From: Clerk Yapton Parish Council [REDACTED]
Sent: 22 June 2011 14:22
To: Planning
Cc: Planning.Responses
Subject: Planning Application Y/15/11
Importance: High

The Planning Committee of Yapton Parish Council has considered this application and the Parish Council wishes to register an **objection** on the following grounds:

Block Plan 1-200 @ A1

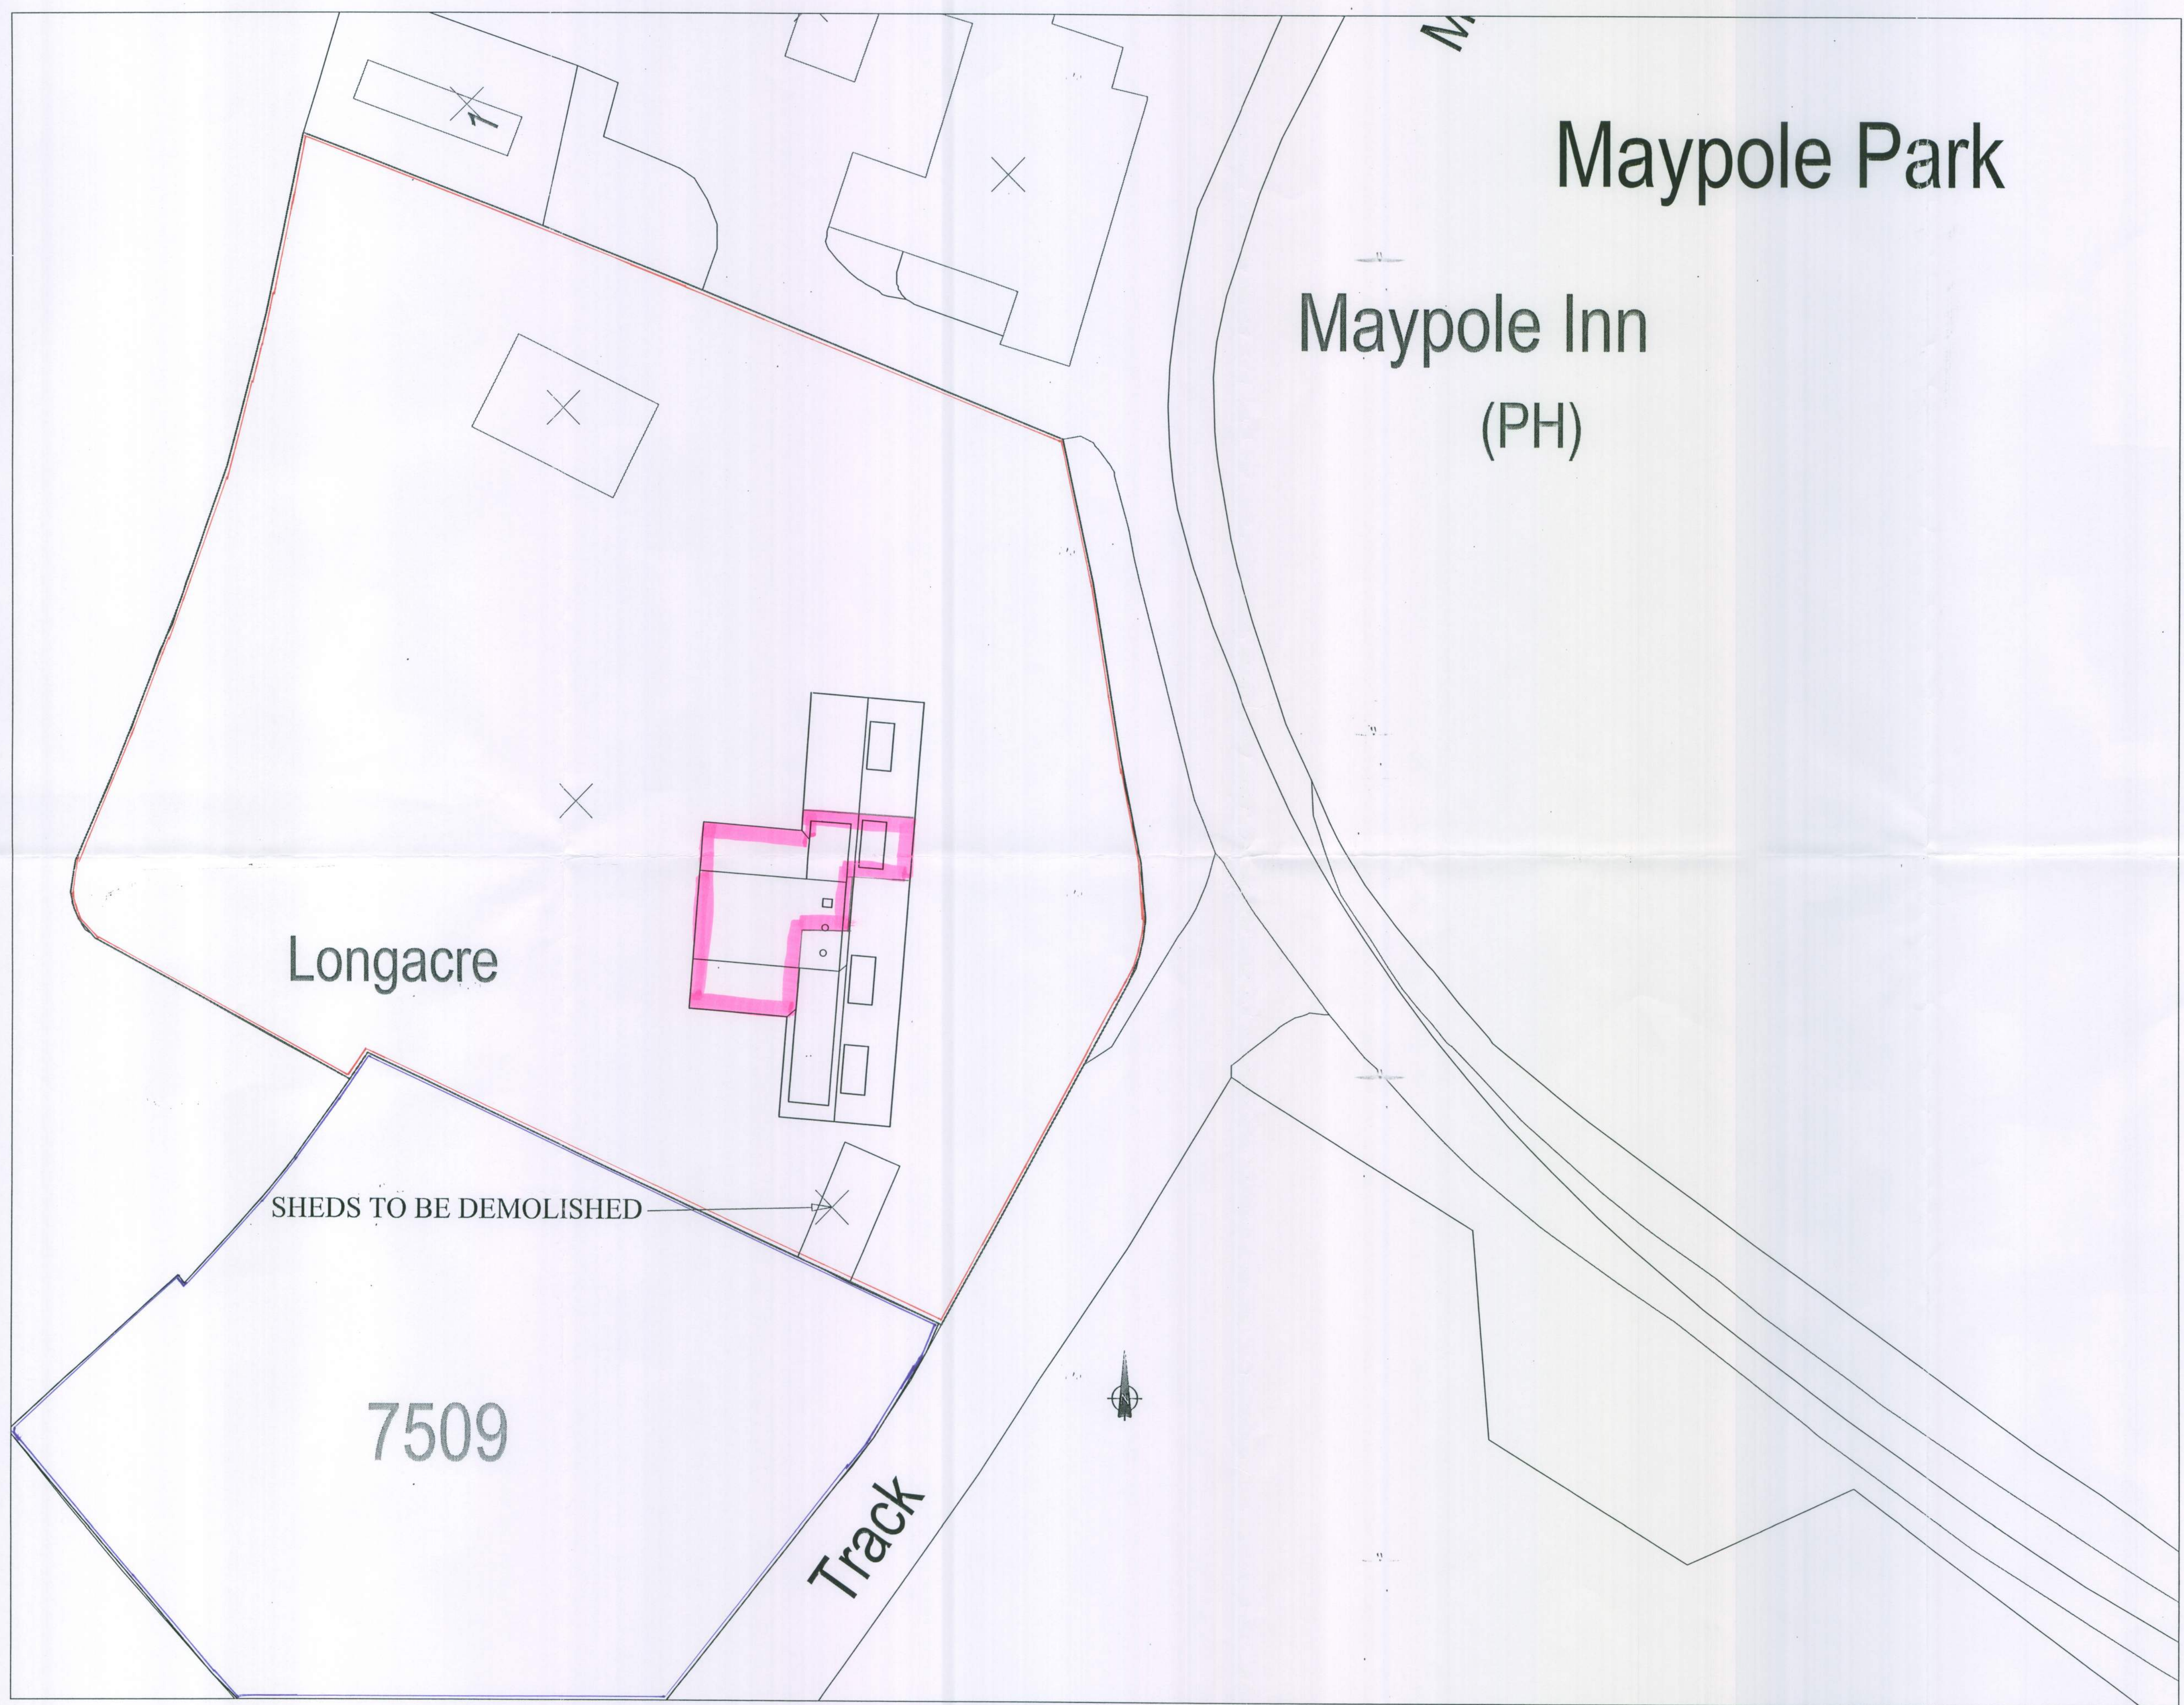
ii) Maypole Lane is a narrow rural lane with no footpaths. In the absence of specific information concerning the numbers of staff, clients and visitors expected to use the facility, the Parish Council has concerns about the following highway safety issues:

- *the arrangements for access;*
- *the visibility of vehicles entering and leaving the site;*
- *the safety of pedestrians and drivers arising from increased traffic movements in Maypole Lane;*
- *the adequacy of the provision for on-site parking of staff, clients and visitors.*
